LU/247/20/PL

57 River Road Littlehampton BN17 5DD

Partial demolition of existing building, retention of boundary wall & street facade, partial demolition of boundary wall to incorporate new pedestrian gateway & gate, erection of 6 No. flats in 2 blocks connected by shared stair & lift core, on site parking yard for 8 No. cars & 8 No. cycles & space for communal refuse & recycling bins

TITLE: PROPOSED SOUTH EAST ELEVATION

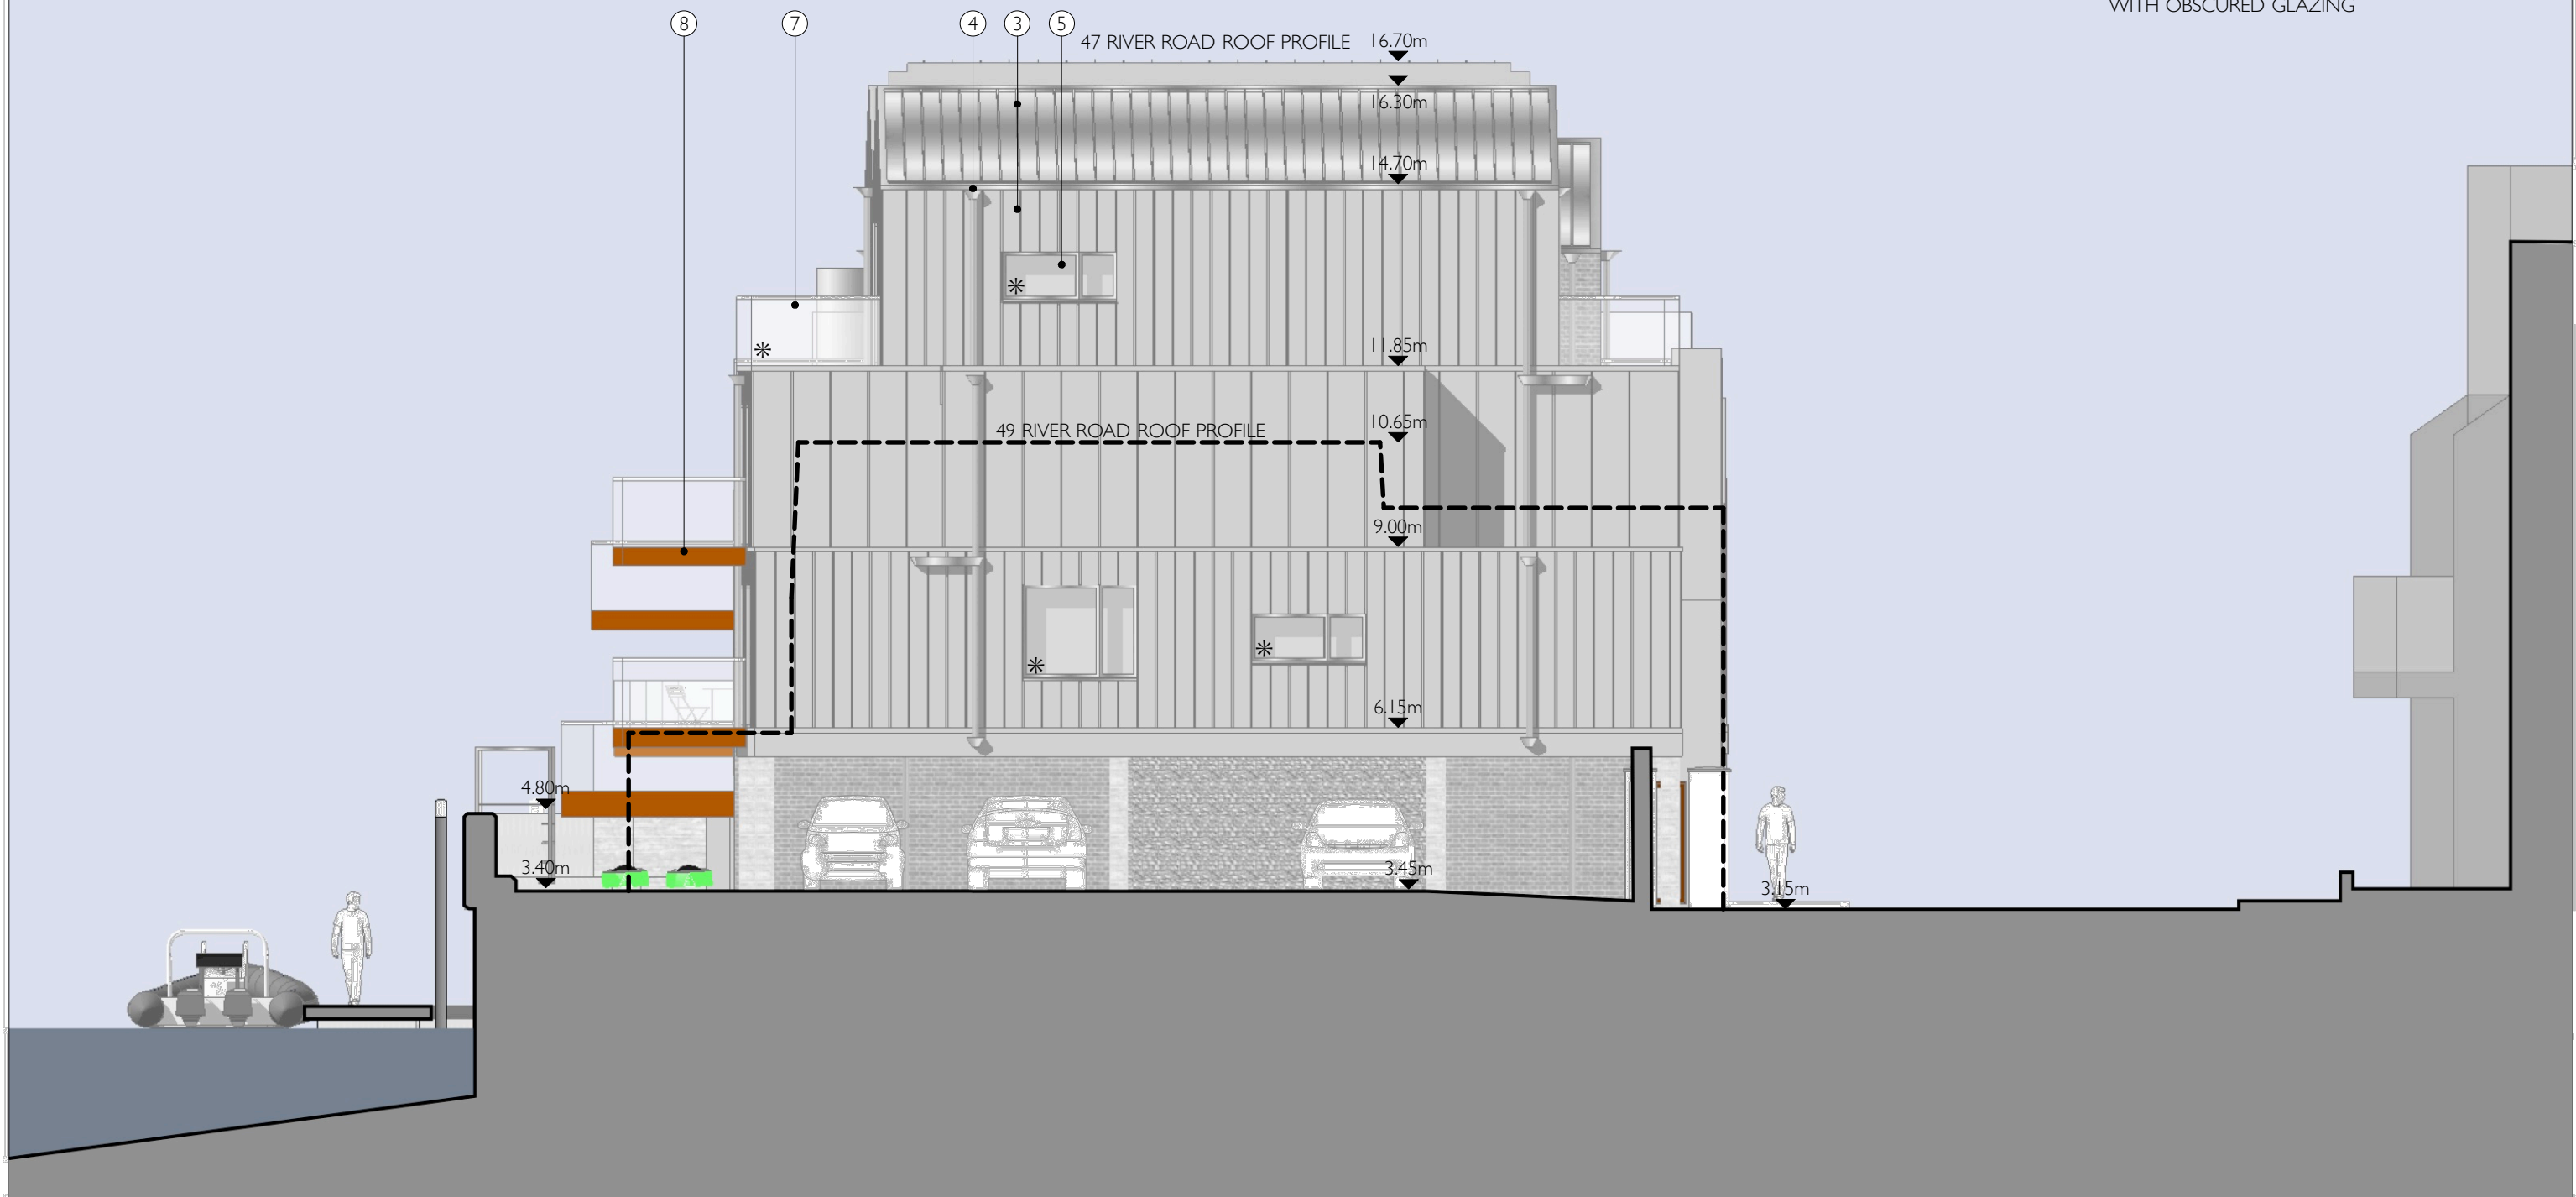
The concept of splitting the building with a glazed area in between seems to be a positive approach. In terms of the impact of the development on the character of the local area it is thought that the southern block may be one floor too high. At present that is quite a difference between the height of the proposed building and the neighbouring heritage asset (a Locally Listed Building or Structure of Character). It is thought that the proposed development at this height would negatively impact on the setting of the asset. It is suggested that a reduction in height would reduce that impact.

I note that in the southern element the two upper storeys are to be metal clad, however it is not clear what the first floor is to be clad with; the drawings indicate that it will be the same. This requires clarification. If you are minded to approve the application details of the materials and joinery should be supplied to the council by way of condition.
